## SUBMISSION TO BOTANY BAY DUPLICATION SSI-9714

This submission has been prepared by Urbis Pty Ltd (**Urbis**) on behalf of Qantas Airways Limited (**Qantas**) in relation to the State Significant Infrastructure Application (**SSIA**) for the Botany Rail Duplication Project (**the Project**).

## Acoustics - Botany Rail Duplication Comments

Figure 3 Site Plan, Receivers and Noise Monitoring Locations

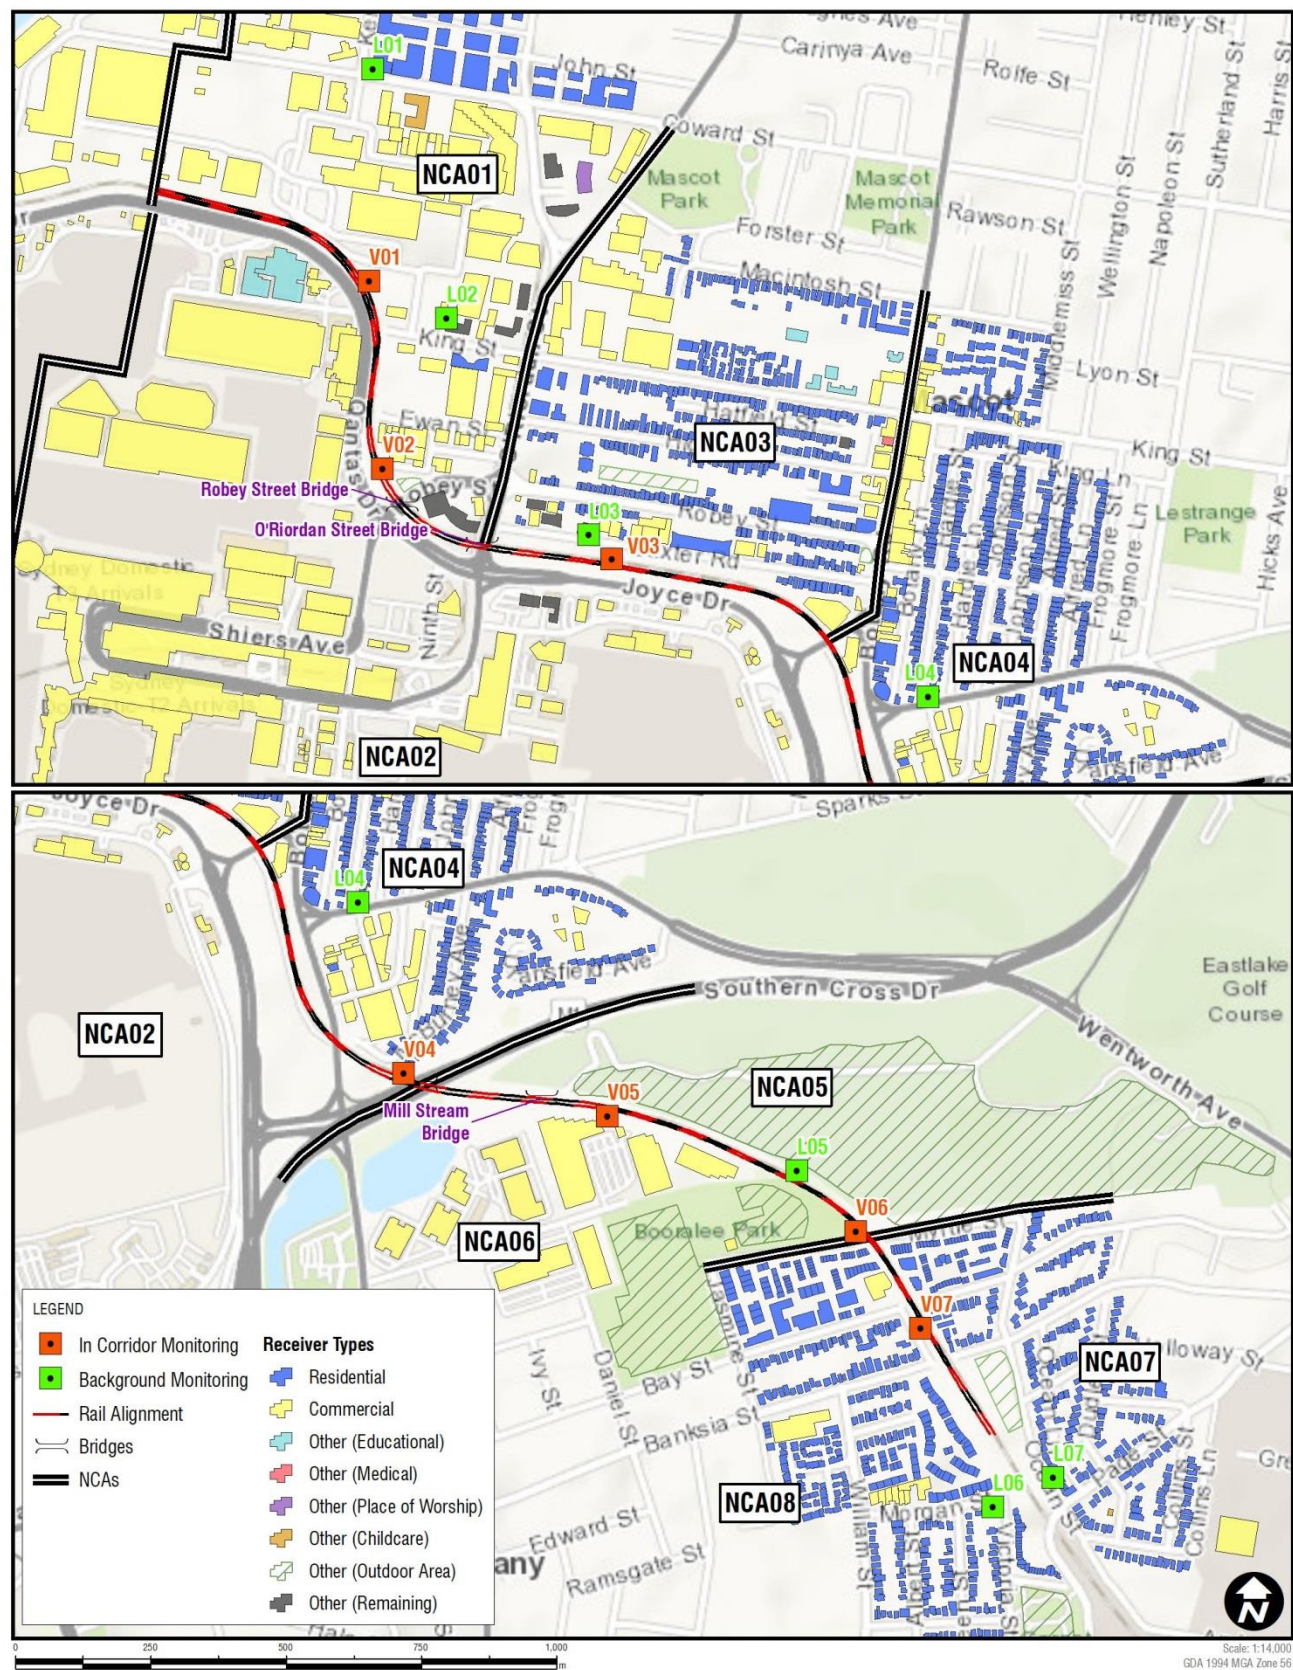
The existing Qantas Flight Training Centre has been identified as an 'Other Sensitive' Receiver (Non-Residential) in Figure 3 of the Noise and Vibration Technical Report. It is of concern to Qantas however, that the documentation has failed to recognise the new Flight Training Centre location as an additional sensitive receiver. This is presumably due to the fact that the new Flight Training Centre is yet to be approved.

As highlighted previously, the SSDA for the new Qantas Flight Training Centre has been recommended for approval by DPIE and has been referred to the IPC for determination. It is therefore anticipated that the approval of the new Flight Training Centre will be granted prior to the approval for the Project. On this basis, it is requested that the new Flight Training Centre is formally listed and assessed as a sensitive receiver as part of the SSIA.

- Both the existing and new Qantas Flight Training Centres are listed as sensitive receivers for the purposes of acoustic and vibration assessments;
- The maximum predicted noise level ( $L_{max}$  level) for the new Qantas Flight Training Centre should be clearly stated in the Noise and Vibration Technical Report to allow Qantas to review impacts.
- Any approval granted for the Botany Rail Duplication contain explicit conditions that place maximum noise and vibration limits on the proposal that reflect the internal noise criteria outlined in Table 1 and 2 to protect Qantas' operational requirements;
